Our Ref: M/26/10/

20th May 2010

Demolish existing prefabricated bungalow and build new 3 bedroom house
32 Ancton Way Elmer Sands

FIRST FLOOR PLAN

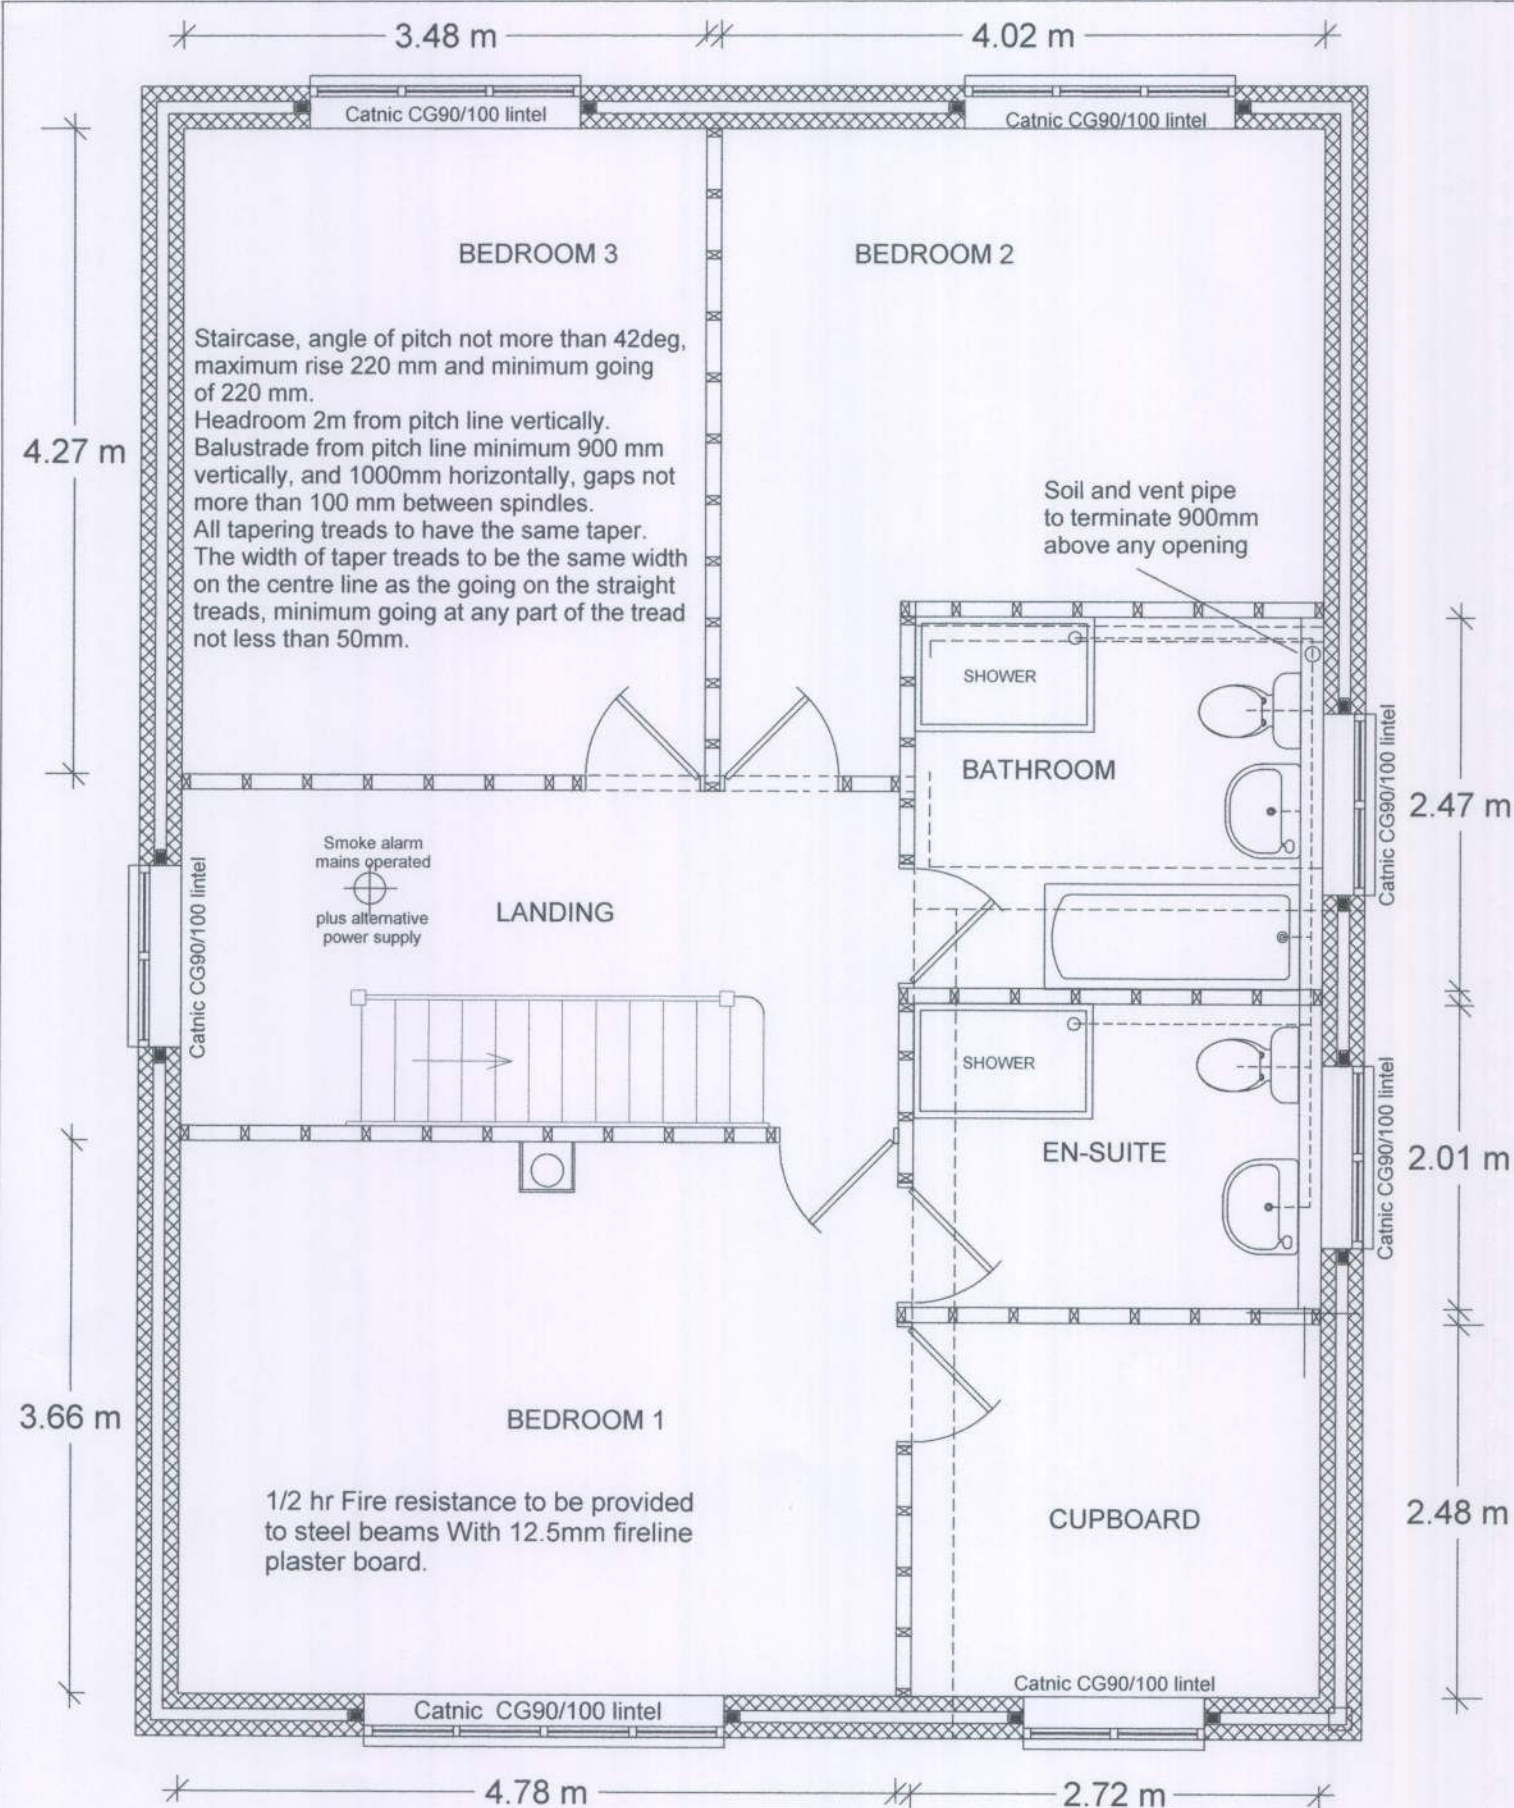
The proposed application demonstrates an unacceptable increase in the load placed on the foul water drainage system as the proposed property has three bathrooms/toilets.

SITE PLAN

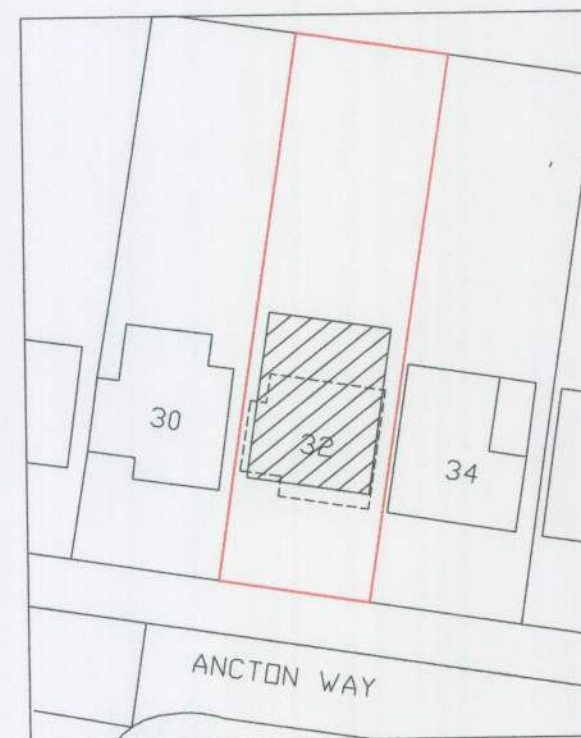
Further, the footprint of the property and roof is much larger than the existing property and disposal of the rainwater is proposed via soakaways. If the committee are minded to approve the application then at a very minimum a recycling system for rainwater should be employed to minimise the effect on local surface water levels/foul water discharges.
